Developer Services
Southern Water
Sparrowgrove House
Sparrowgrove
Otterbourne
Hampshire
SO21 2SW

Your Ref
WA/47/18/HH
Our Ref
PLAN-023350
Date
03/07/2018

Proposal: Single & two storey extension & alterations.
Site: 12 Barnfield Cottages Arundel Road Fontwell Walberton BN18 0SE.
WA/47/18/HH

C		
B		
A		
Client	Mr & Mrs Mole	
Address	12 Barnfield Cottages: Arundel Road	
Drawing	Location plans	No. 2818:2
Scale	1:500 1:1250	Drawn <i>AS</i> Date <i>MAY '13</i>

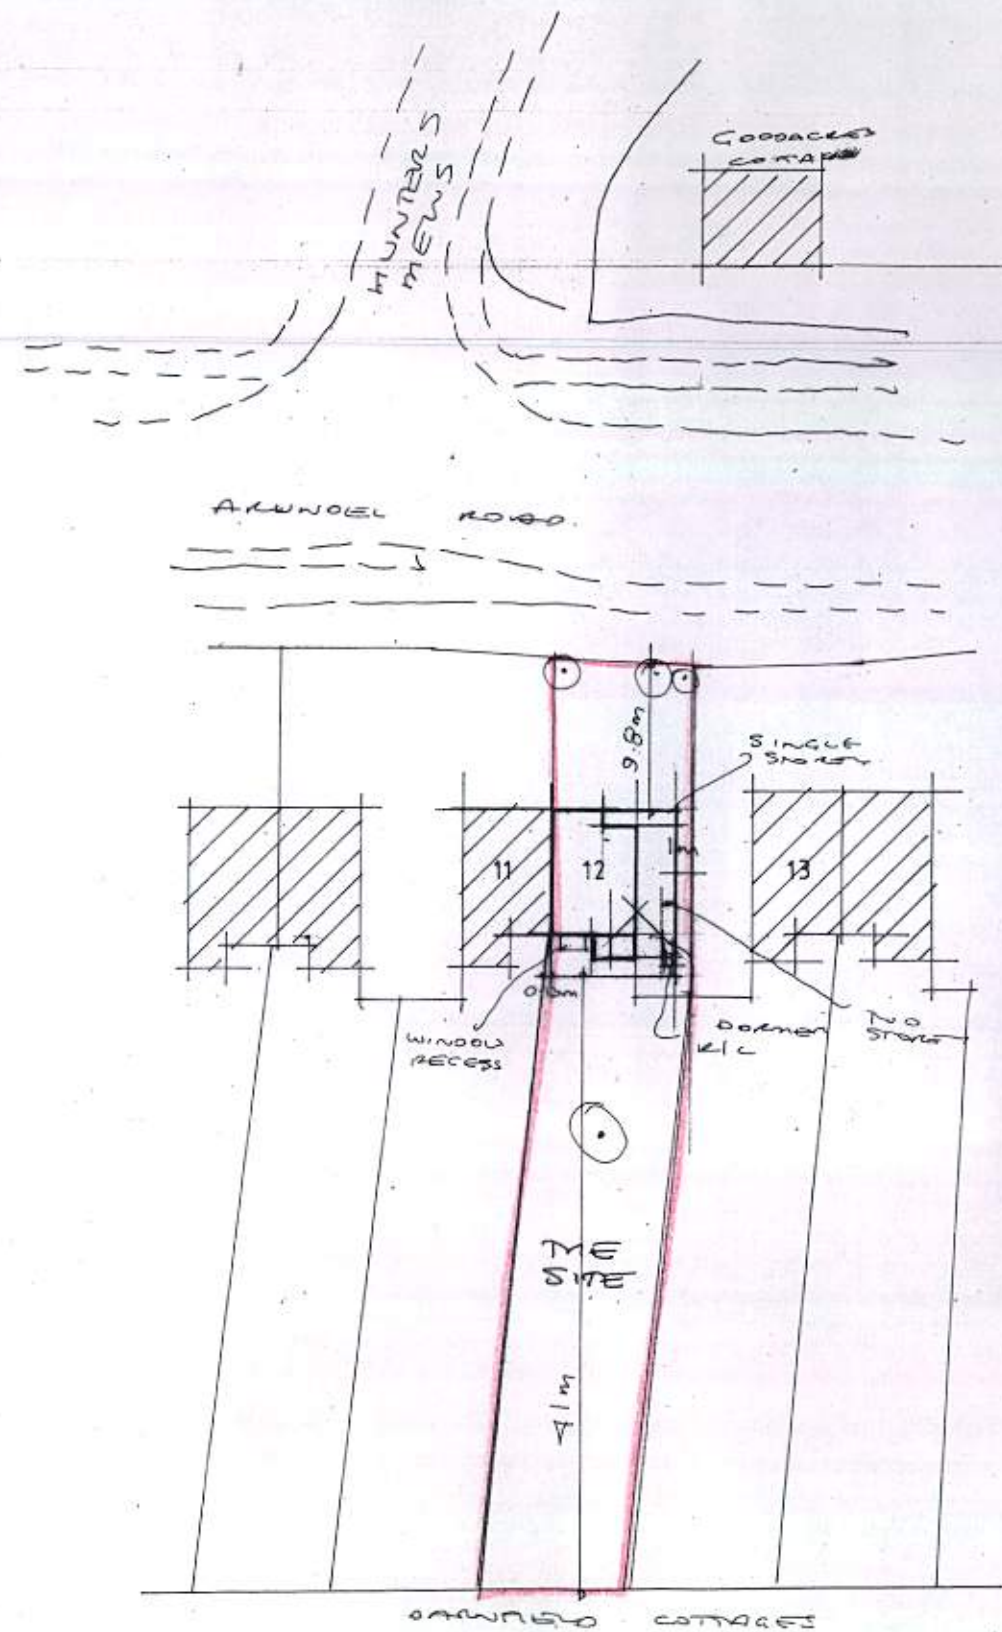
Please find attached a plan of the sewer records showing the approximate position of a public sewer within the site. The exact position of the public sewers must be determined on site by the applicant before the layout of the proposed development is finalised.

No development or new tree planting should be located within 3 metres either side of the external edge of the public sewer and all existing infrastructure should be protected during the course of construction works.

No new soakaways should be located within 5 metres of a public sewer.
